One Carrington SSD and Concept Plan (Mod 2)

Attachment A - Response to Department's Key Issues

Comment	Response
CONCEPT PLAN MODIFICATION (MP09_0076 MOD2)	
Public Benefits	
1. The current proposal amends the proposed Transit Hall and includes additional floor space and 285 George Street. The following additional information is required:	See below.

18 SEPTEMBER '14
SCALE 1:250 @ A3
13S1213000-04-05-P4

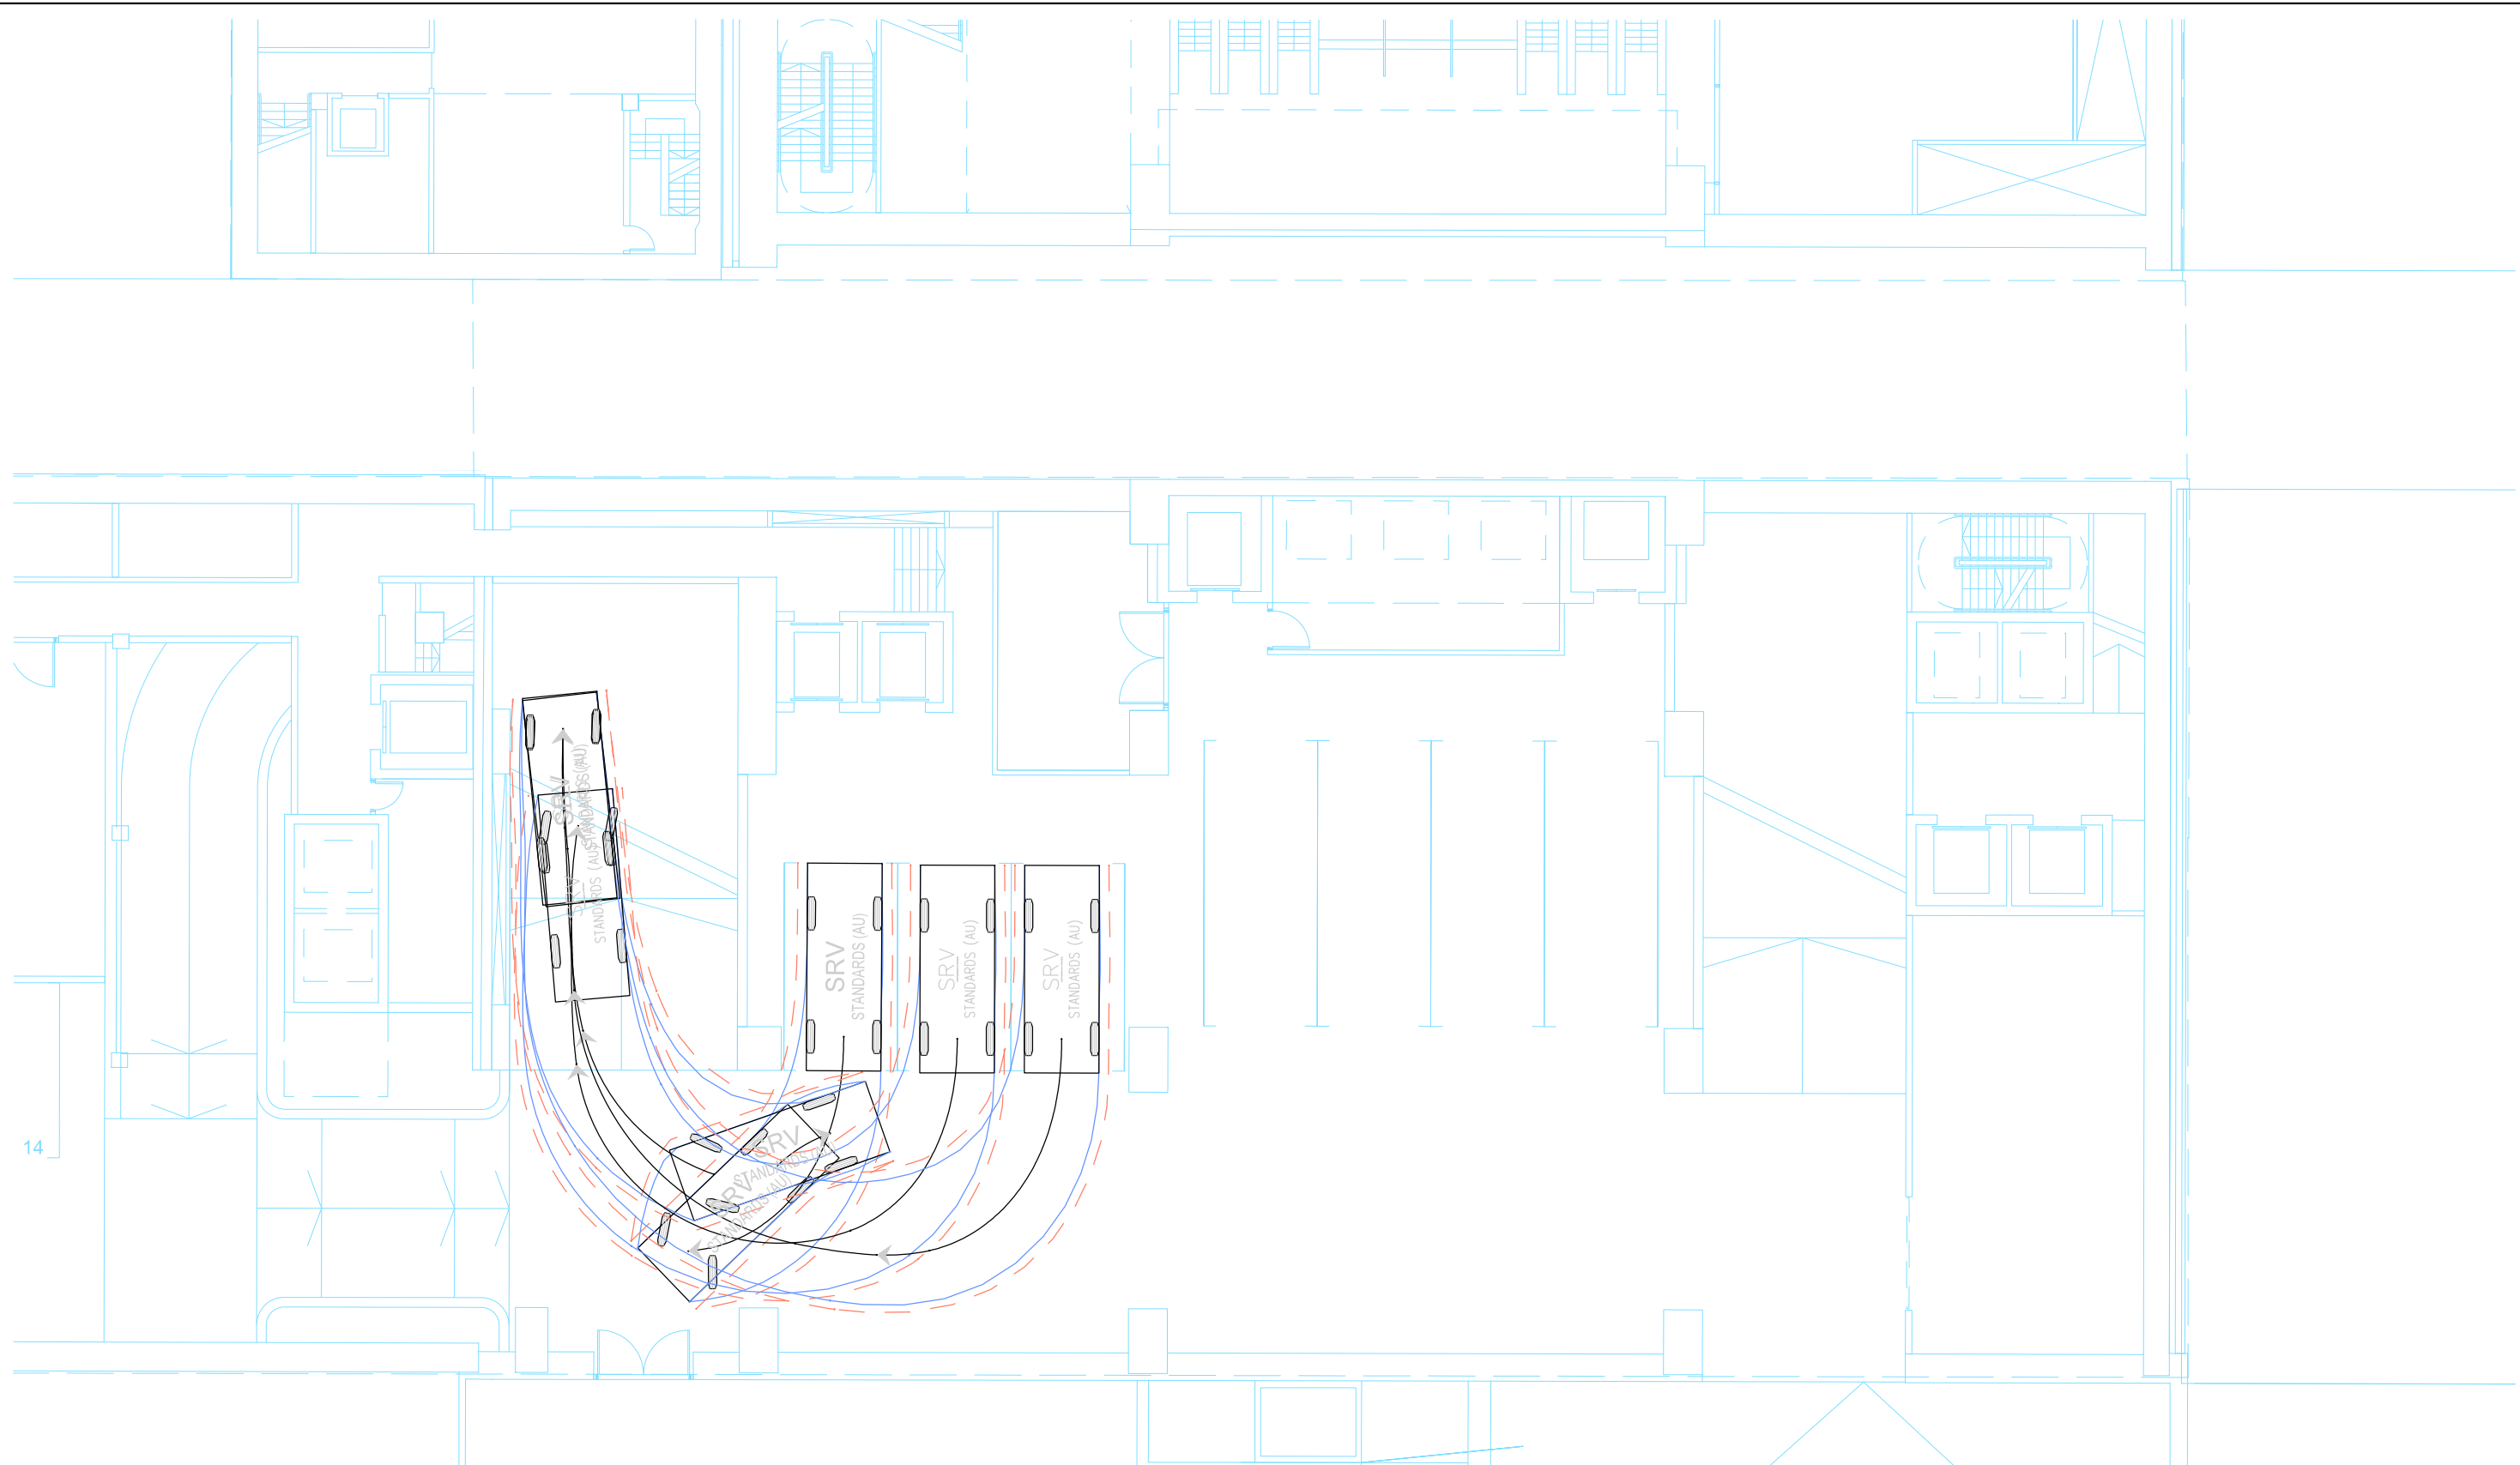
a. vehicle swept path analysis confirming that:	An analysis prepared by GTA Consultants (GTA) regarding the detailed issues raised under each of these sub-points is located in Attachment G . This vehicle swept path analysis confirms <i>service vehicles can enter and exit from the proposed loading dock and basement car park entry/exit points from Wynyard Lane; the proposed loading bays can be accessed in a reasonable manner; and the 'one-way aisle' providing access to the loading bays can accommodate necessary vehicle manoeuvres</i> . We trust the attached information sufficiently responds to these matters

i. service vehicles can enter and exit from the two proposed loading dock and basement car park entry/exit points from Wynyard Lane;	
ii. the proposed loading bays can be accessed in a reasonable manner ; and	
iii. the 'one-way aisle' providing access to the loading bays can accommodate necessary vehicle manoeuvres .

12. The following additional information is required regarding the access to and operation of the basement level servicing area:	The loading dock has been designed in accordance with the Australian Standard. A swept path analysis has been provided at Appendix S of SSD submission that confirms that there would be no issues with vehicle turning geometry for vehicles up to an 8.8m MRV.
